City of Albuquerque Stormwater Construction Site Inspection Report

ESC File No.	C18E075	Project Name:	Sevano Place Subdivision		
NPDES Id. No.	NMR10039R/NMR10039X/N MR1003B0	Location:	6300 Alameda Blvd. NE		
12/28/2021	Owner	owner & Contractor			
Operator	Sevano, LLC.	Stillbrooke Homes			
Contact name & title	Shakeel Rizvi	Chris Kelsey			
e-mail	shaky1424@yahoo.com	ckelsey@stillbrooke.com			
Contact Phone #	505-315-6563	505-858-1800			
COA Inspector	Doug Hughes	Start/End Time:	1pm		
Construction Phase:	infrastructure				
Type of Inspection:		Storm Event	Past Storm Event >0.25"	311/Complaint	Follow Up
Weather at time of inspection?		Cloudy	Temperature: ~		47
Estimated date of last storm 0.25" or greater		10/1/2021

SEVANO DEVELOPMENT, LLC
SEVANO PLACE SUBDIVISION
TESCP

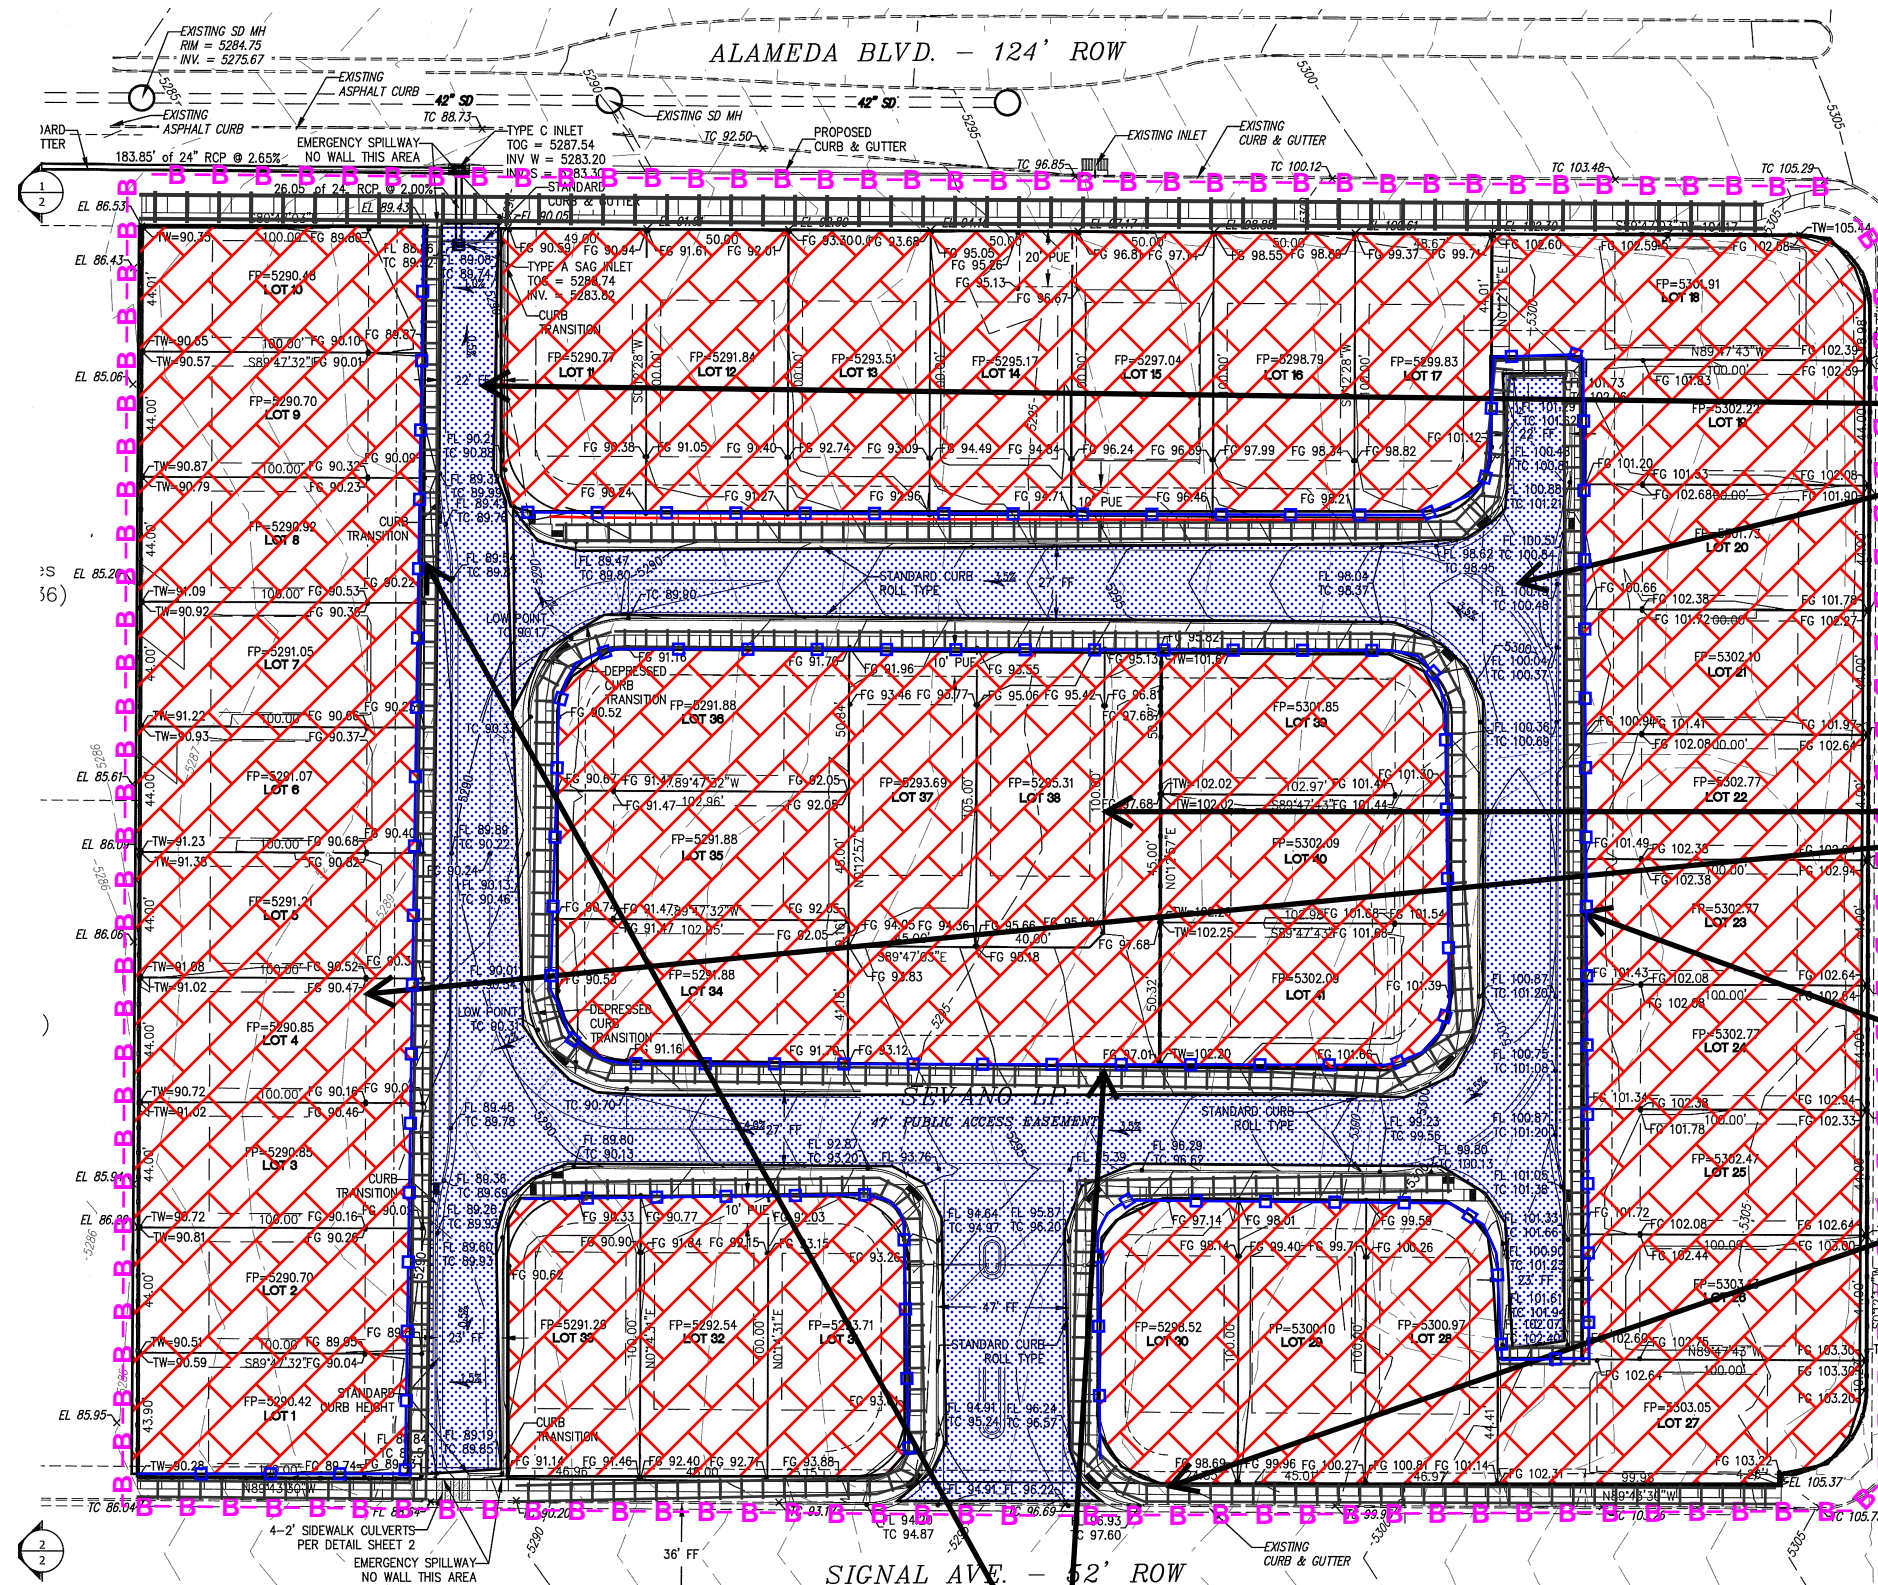
Item Number	Deficiency/ Corrective Action				
1	SWPPP map should not only identify the lots sold to Stillbrooke but also the finished occupied houses (3 or 4 now). Stillbrook's NOI (NMR1003UE) still missing from SWPPP				
2	Concrete, paint, and stucco washout still on the ground. Provide more washouts containers and pickup existing washout..
